HIGHWAYS ENGLAND RESPONSE

Proposed M4 Junctions 3 to 12 Smart Motorway:

Written Representation & Accompanied Site Inspection

Figure 6 – Construction Compound 8

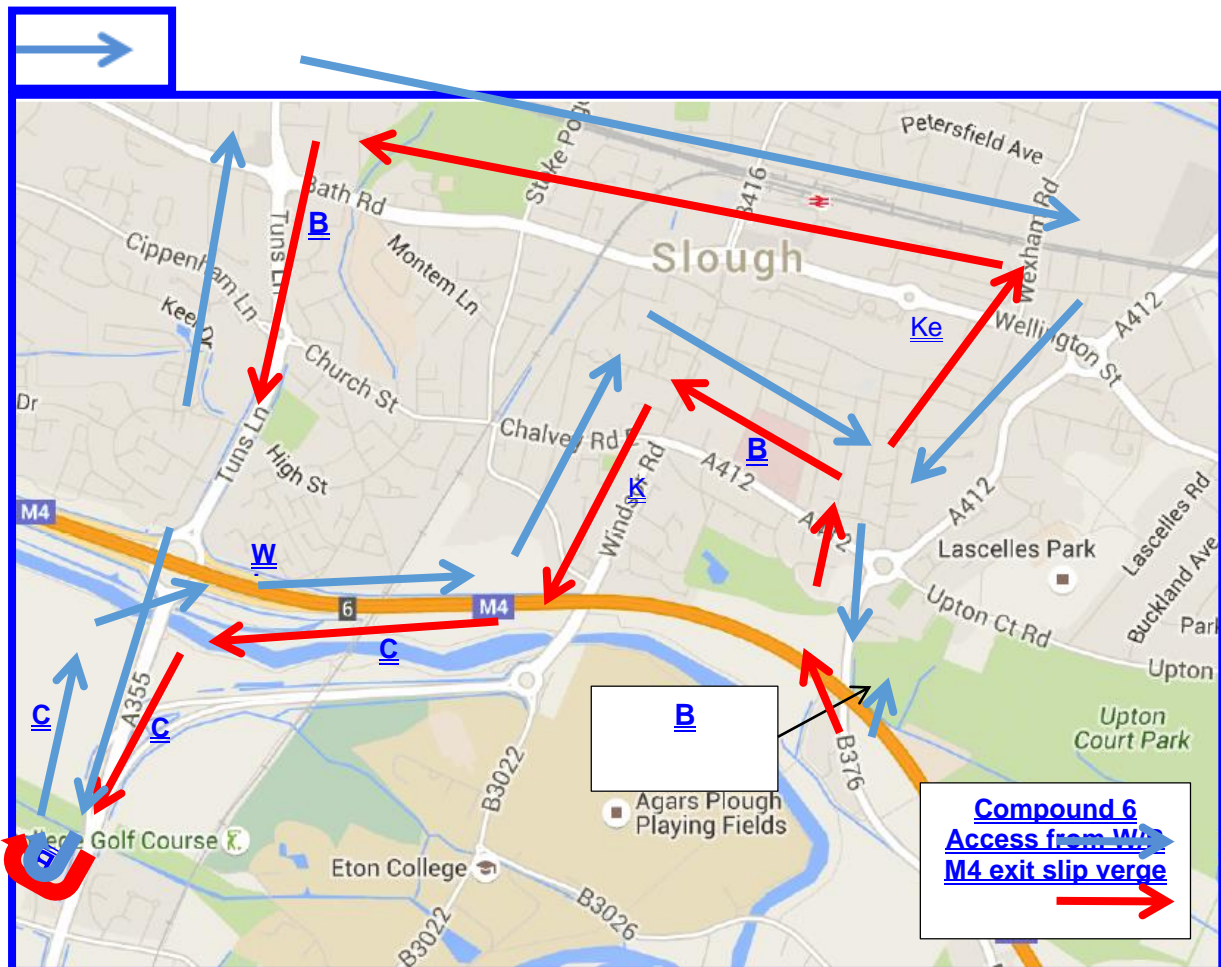
2.2 *Proposed construction compound 8 is only 35 metres from some homes on The Myrke and, according to the application, there may be significant night time noise impacts and potential adverse effects from construction dust, and therefore air quality, on homes in The Myrke (assessment ref 14.10.23 Main Text). There are alternative sites that are further away from residential property (e.g. construction compound 7) with noise impacts "unlikely to be significant" so we strongly urge the ExA to remove compound 8 from consideration to reduce the impact on local residents in the event that the application is approved.*

- 2.3 *Four of the proposed construction compounds (1, 10, 12 & 13) were deleted by the HA from the application; two of these were removed due to the potential disturbance to a traveller park (13) and to a hotel (12). Surely permanent residents of The Myrke should be afforded similar consideration and compound 8 removed from consideration.*

- 2.2.1 The proposed Construction Compound 8 is sited in a triangle of land on the opposite side of the B376 Datchet Road to the homes on The Myrke. The boundary of the land for the proposed Construction Compound 8, at its closest point, is approximately 50m to houses and 35m to residential gardens. At this location a substantial screen of trees and shrubs exists between the west-side of the B376 and the properties of The Myrke. The construction of the new bridge and the compound should not require these trees and shrubs to be removed at this location, as shown in the Engineering and Design Report ("EDR") (Application Document Reference 7.3), Annex A1, Environmental Masterplan Sheet 23.

- 2.2.2 If Construction Compound 8 could not be used during the construction phase, the nearest alternative would be Construction Compound 7, which at over 2km away from the bridges would be impracticable due to such a distance. Compound 7 will be used during the construction of the Windsor Rail Bridge and is also not of sufficient size to be able to accommodate the construction of the other structures.

- 2.2.4 Proposed Construction Compound 8 is planned to be used to support the demolition and construction of Datchet Road, Recreation Road and Riding Court Road bridges. Datchet Road and Recreation Road bridges are immediately adjacent to the north eastern and south eastern boundaries of the proposed Compound. The immediate proximity of the proposed compound to the structures is essential for the construction of these bridges.

- 2.2.7 Areas of the compound that would be heavily trafficked will be surfaced with tarmacadam to minimise dust. Dust suppression via water spraying would be carried out to un-surfaced areas to minimise airborne dust. The screen of trees and shrubs between the compound and residential properties will assist in the prevention of dust nuisance.
